August 10, 2023

Re: Ideal Industrial Park-Response to Technical Review 1- PA23010

The following is our response to comments in your Technical Review letter of July 20, 2023, to Merle Ash.

SHEET: **A1.0**

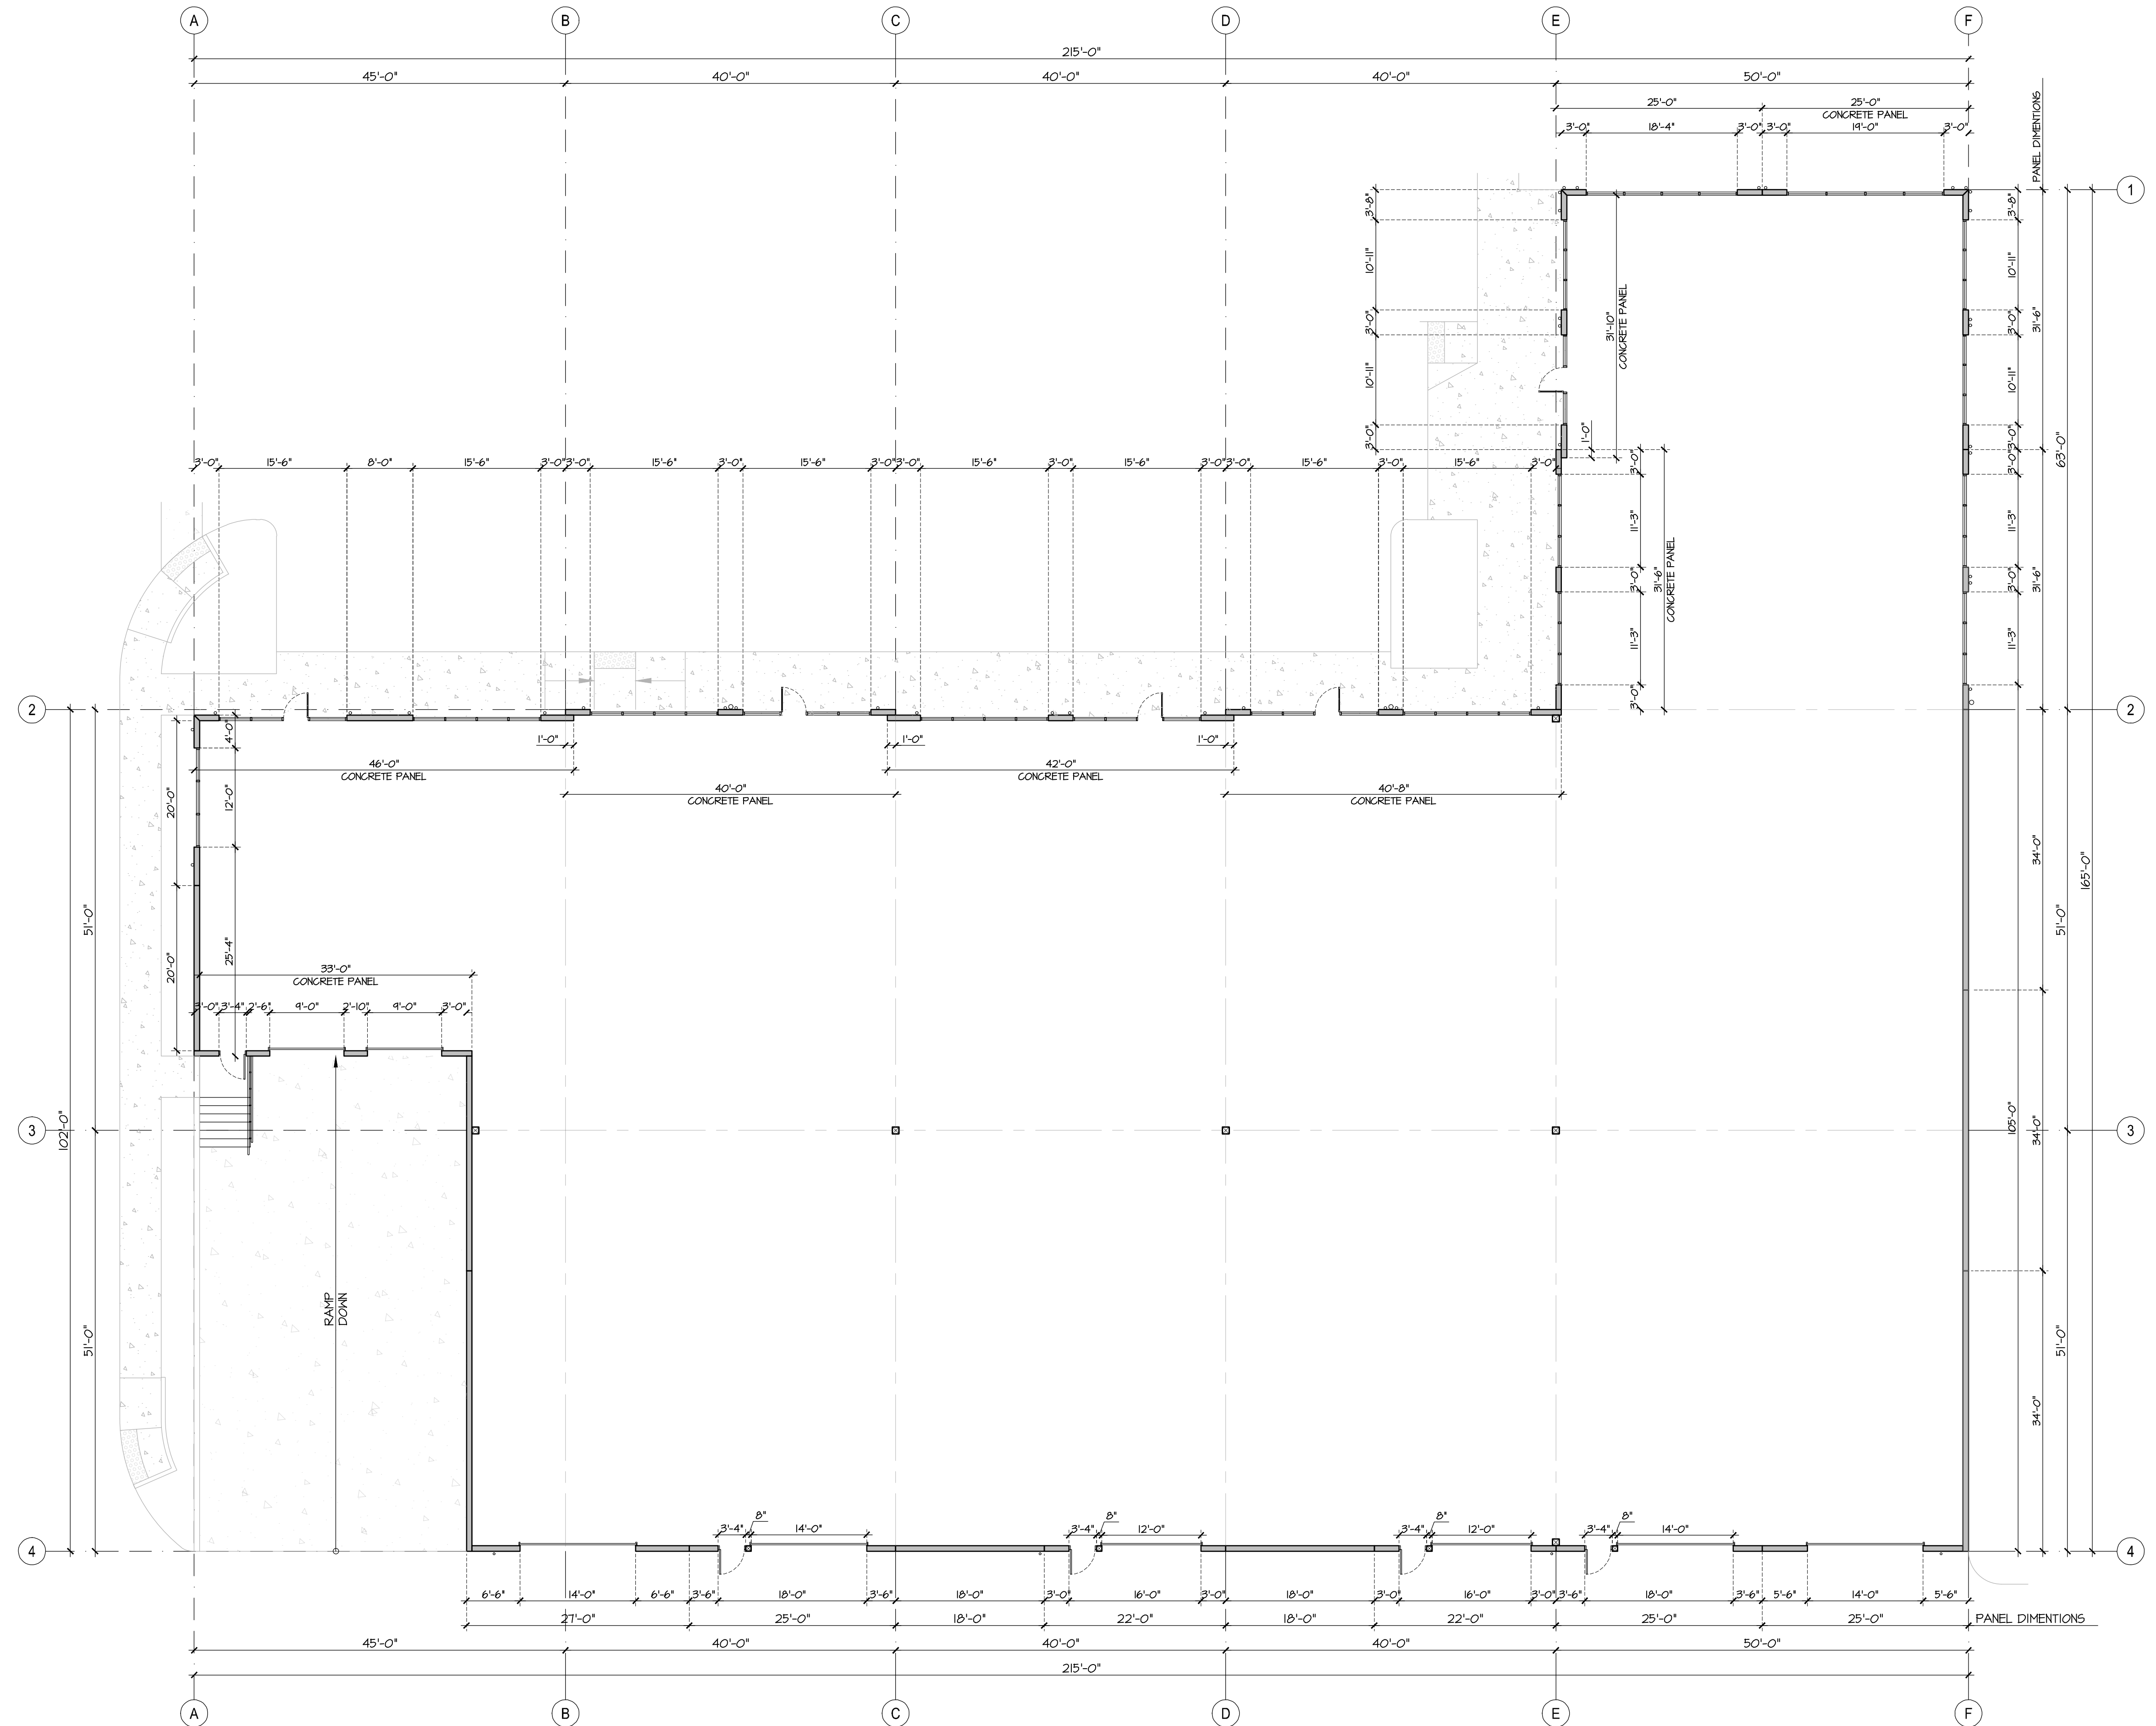
4. Sheet P-1
  - a. 18ft stalls are shown with a 2ft overhang at landscaping and a 2 ft overhang at private sidewalks that are at least 7ft wide to allow for a net width of 5ft. This is a safer solution than wheel stops that are a trip hazard with legal liability and make lots harder to keep clean.

- b. 10 bike stalls are shown on the plans.
  - c. Pedestrian walkways will be patterned or broom finish concrete to contrast with the asphalt.
  - d. Note is amended to read: Per "MMC 22C.020.340(2) any mechanical..."

- e. Amend notes as listed in comment letter. The 7 paragraph notes will be added to P-1.
5. The property is under one ownership now, so an updated Title Report is being ordered with updated notes regarding encumbrances not noted.

ELEVATIONS BLDG A
LANCIE MUELLER & ASSOCIATES
ARCHITECTS
130 LAKESIDE • SUITE 250 • SEATTLE, WA 98122 • (206) 325-2553
SHEET: **A3.0-A**

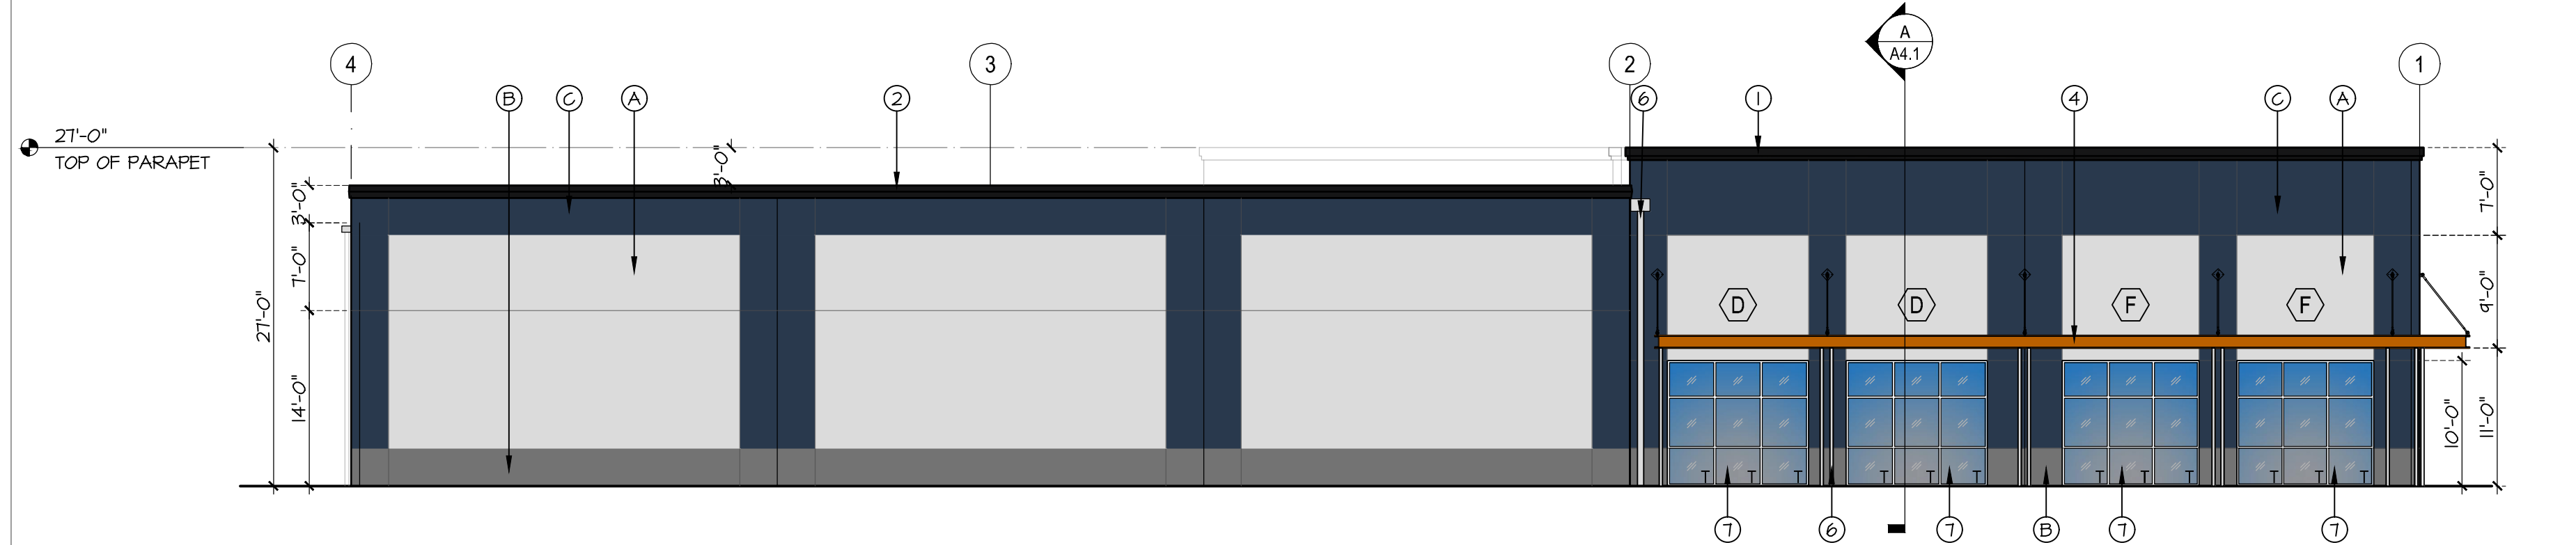
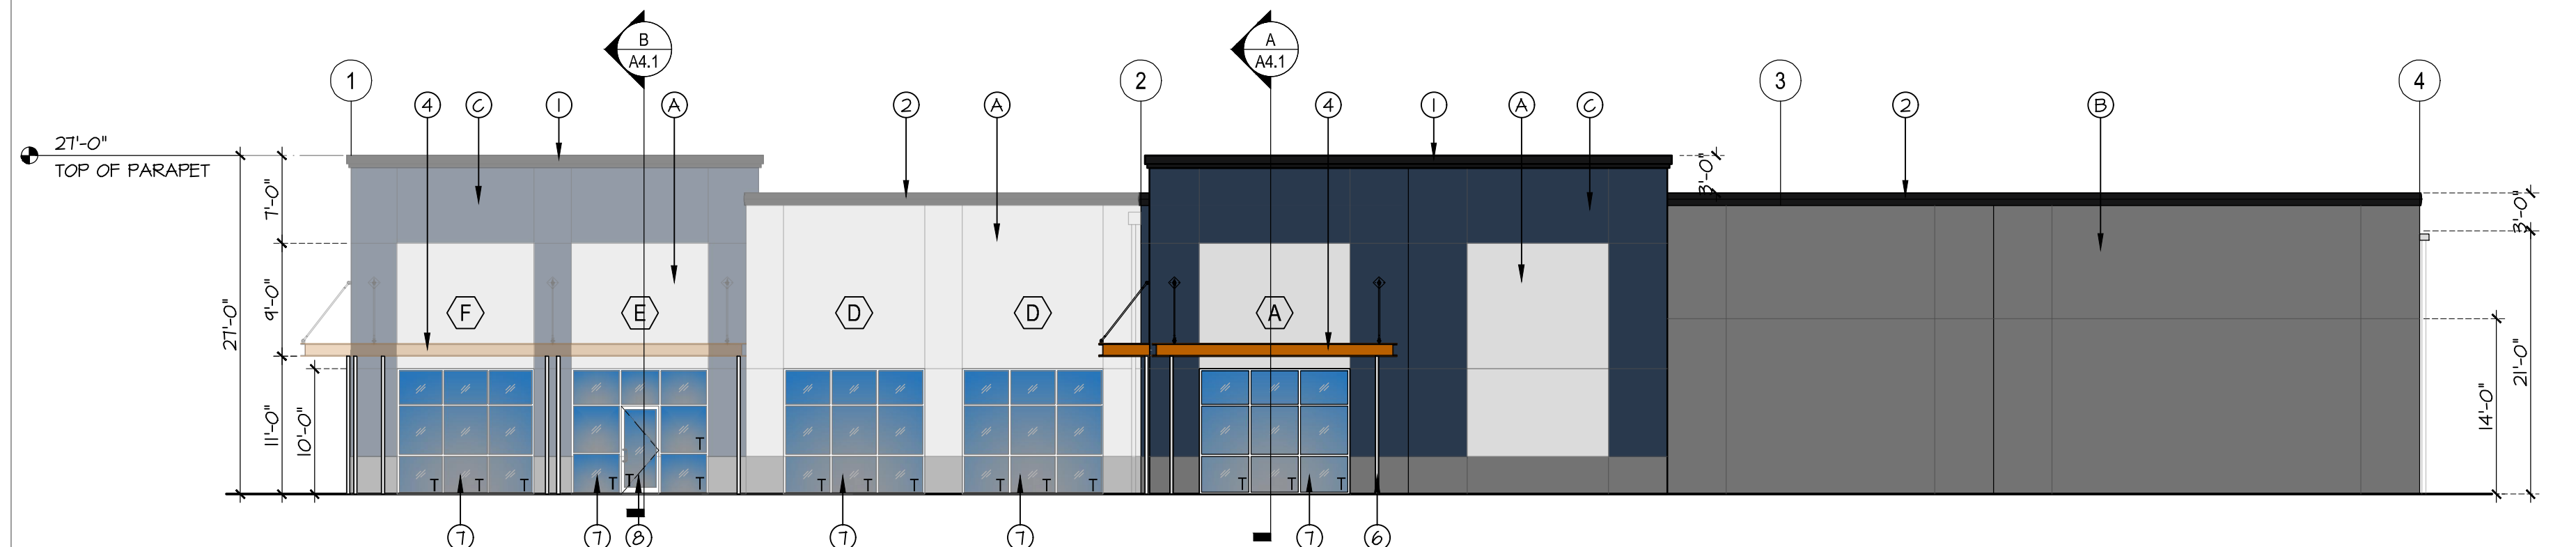
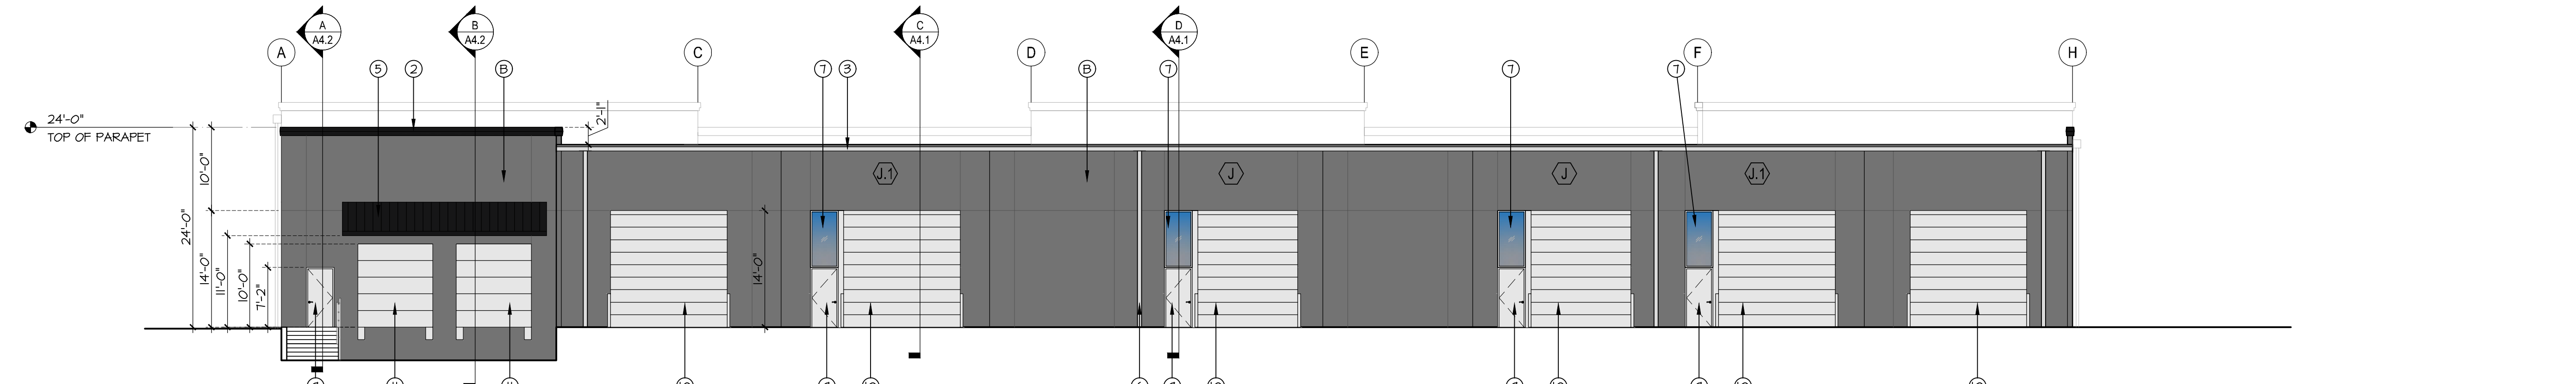
- (a) Façade Modulation. (iii) The proposal is to provide overlapped concrete wall panels that provide changes to the wall plane in combination with the pattern of concrete support elements and two different canopy designs with different colors plus roofline modulation as a departure from 6. (a)(ii)

- (b) Façade Articulation. (i) The walls are all site cast concrete with the “base” defined by paint color, the “middle” is defined by the glass storefront topped with two different canopy designs, and paint color change, and the “top” has a contrasting color wall coping that will project from the wall.

- (ii) The articulation features include (A) storefront windows, (B) weather protection, (C) roof line changes in height, (E) vertical concrete piers/columns between storefronts, (G) strong horizontal and vertical reveals.

- (7) Building Materials. Building materials are of high quality. Walls are structural site-cast concrete, painted. Insulated glazing and aluminum framing are the storefront system. Factory finished ribbed metal roofing at sloped canopies and painted structural steel components at horizontal canopies.

- (8) Blank Walls. Windows had been added to Blank Walls to comply with (8)(b) (i).
